**Consultation Response from KC,
Highways Development Management**

2025/91001 land at, St Luke's, Bierley Marsh, East Bierley, BD4 6PL

**Discharge of details reserved by condition 5 (access re-surface) on previous permission
2020/94345 (APP/Z4718/W/21/3289729) for erection of 5 dwellings**

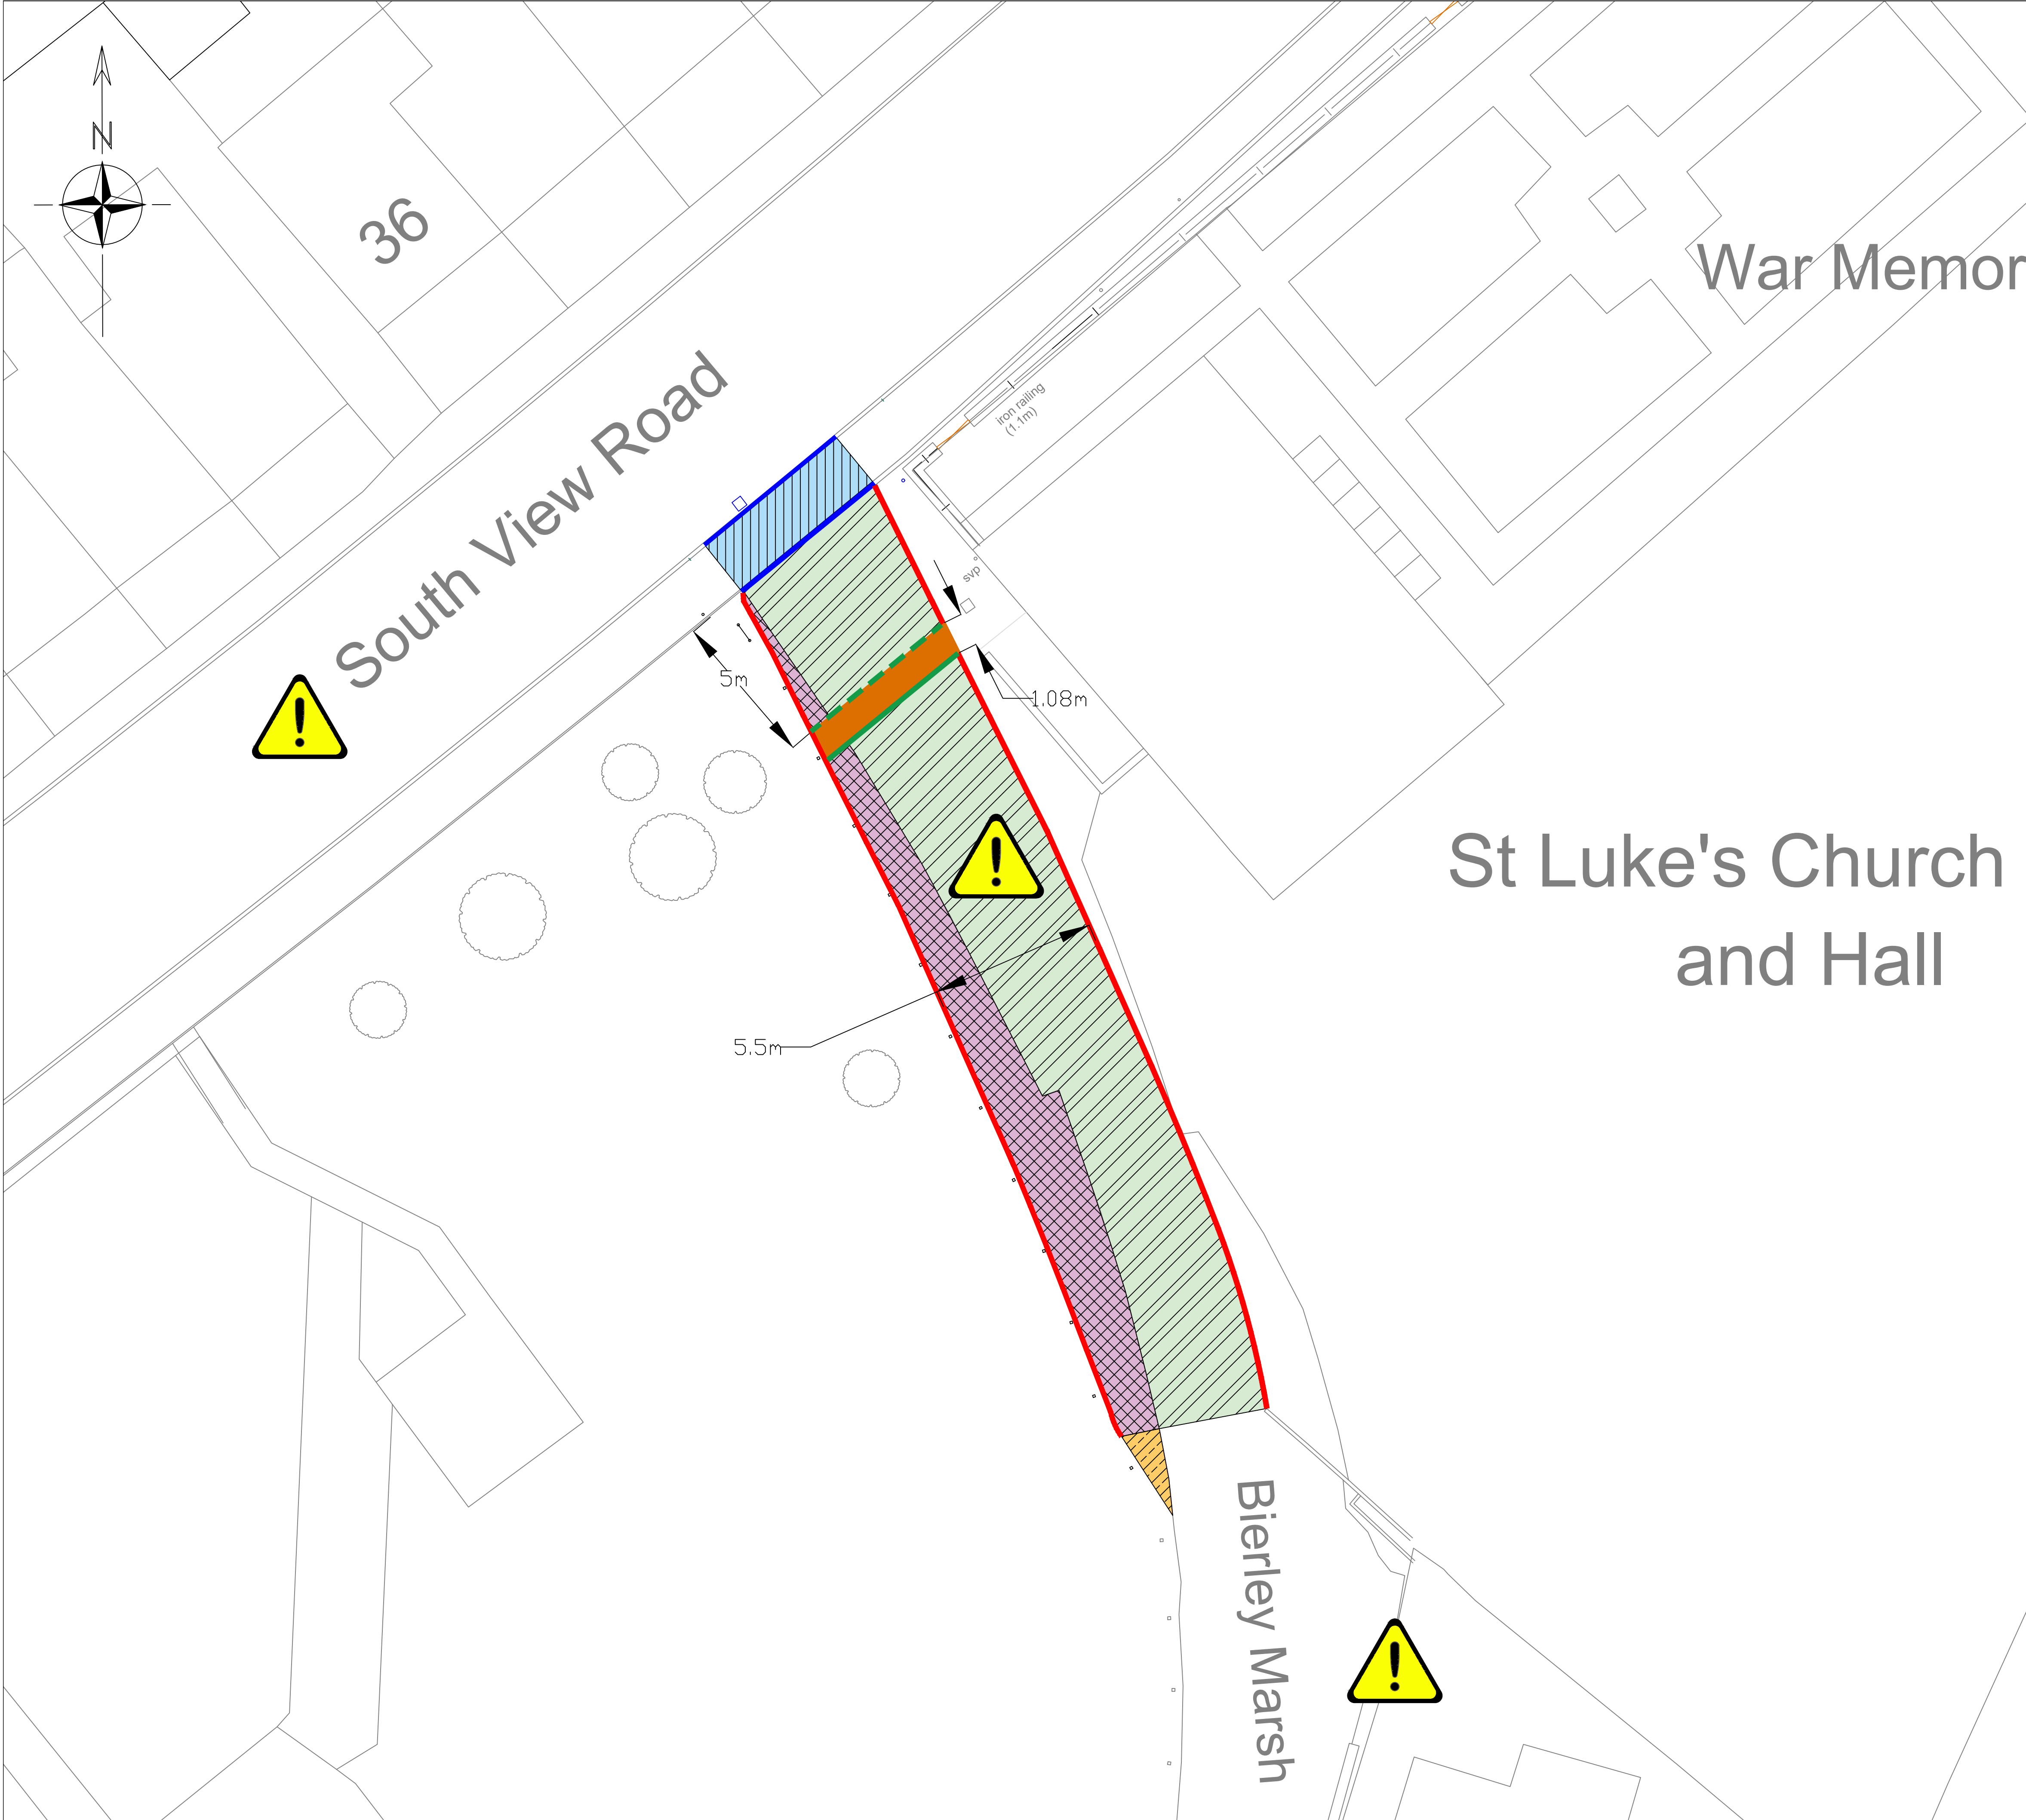
Highways Development Management would however recommend that the ramp at the site entrance (coloured brown on the MCB plan) is omitted as this is not needed.

The tie in between the widened section of Bierley Marsh and the existing (shown yellow and cross hatched with solid and dashed lines on the MCB plan) should be tarmac and not topsoil and seed as shown
